City of Albuquerque
Stormwater Construction Site
Inspection Report

Project Name and Location	SONIC Drive-in 6310 4th St NW		
Site Contact Name & Agency	Norman Hawthorn site sup	ESC File No.	E15E017
Date of Inspection	10-23-17	Start/End Time	12:20 / 12:21
Inspector Name, COA Dept.	Curtis Cherne, Stormwater Quality		
Describe Present Phase of Construction	Stabilized

From: Cherne, Curtis
Sent: Friday, October 14, 2016 3:44 PM
To: 'nhathorn@aol.com'
Subject: Sonic Drive in SWPPP inspection
Attachments: silt_fence.jpg; silt_fence_stake.jpg; concrete_washout.jpg

SWPPP DETAILS FOR SONIC  
NORTH FOURTH NW  
6310 NORTH FOURTH STREET NW., ALBUQUERQUE, NEW MEXICO

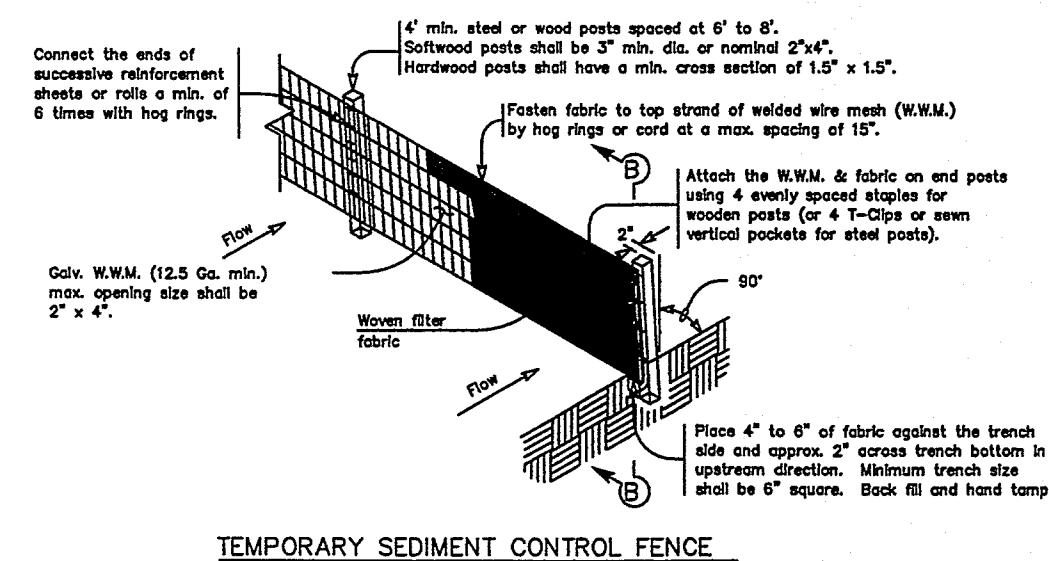
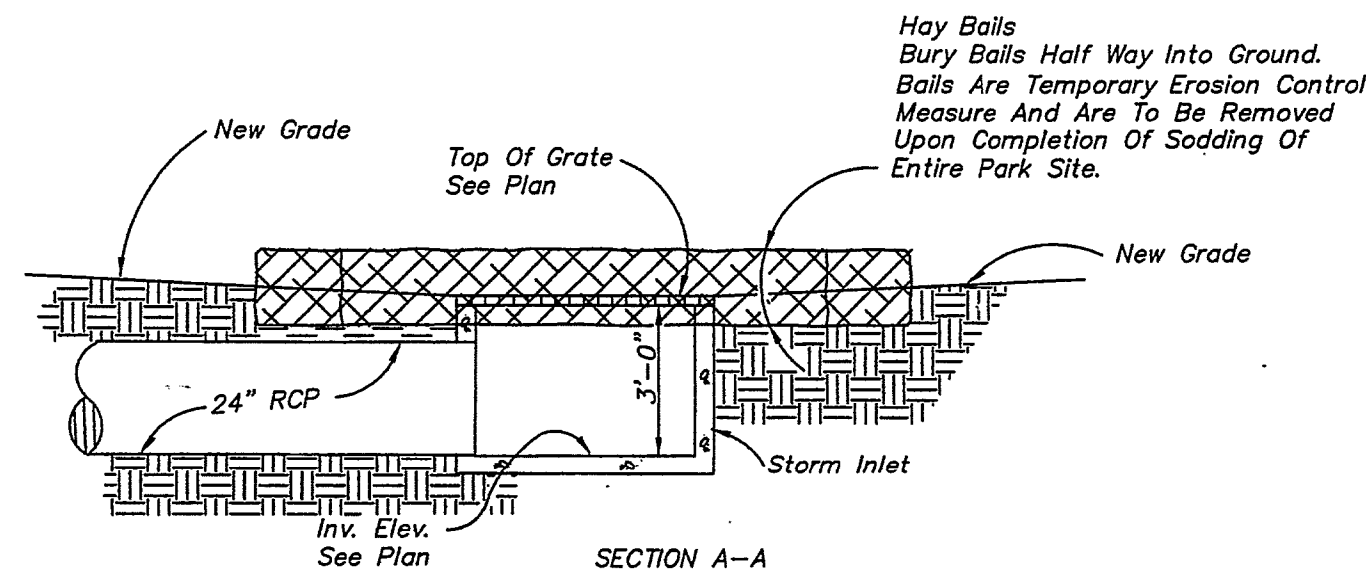
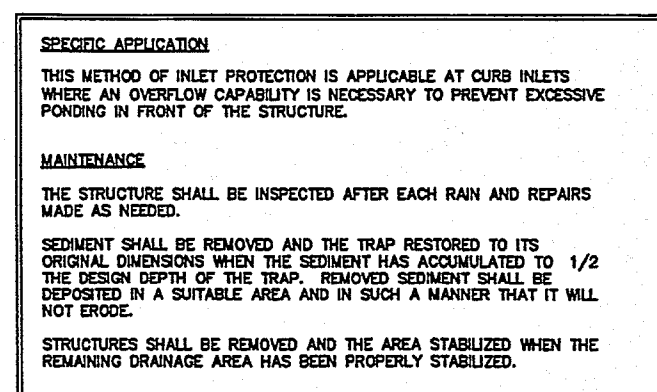
- Entrance / Track-Out semi-erect, no fabric
- Sediment Controls / Silt Fence, Check Dams, Waddles, etc. Silt fence not buried, poles too small 1"x1" Remove and replace
- Erosion Controls / Mulch, Seed, _____
- Housekeeping/Pollutant Controls concrete wash-out NO tar wash-out on site
- Debris/Pollutants/Sediment in MS4 NO
- Notes Spoke w/ Norman about cement pollution and proper silt fence install/attr and proper construction entrance installed

1. The silt fence was not buried and the stakes were too small. Folks use 2"x2" wood stakes or metal stakes used for barb wire. The silt fence needs to be reinstalled. I noticed you weren't using wire-backed silt fence. You will get way more life out of the wire-backed silt fence. If installed properly, it should last the duration of your project with little/no maintenance.
2. Concrete wash-out was observed and I did not see an acceptable wash-out on-site. Please remove wash-out from the dirt and bring in or build an acceptable wash-out.

The entrance looked OK today, but I did not see any fabric underneath it. The fabric provides a barrier so the rock will not "mush" into the dirt and will require less maintenance.

Standard mitigation time is seven days.
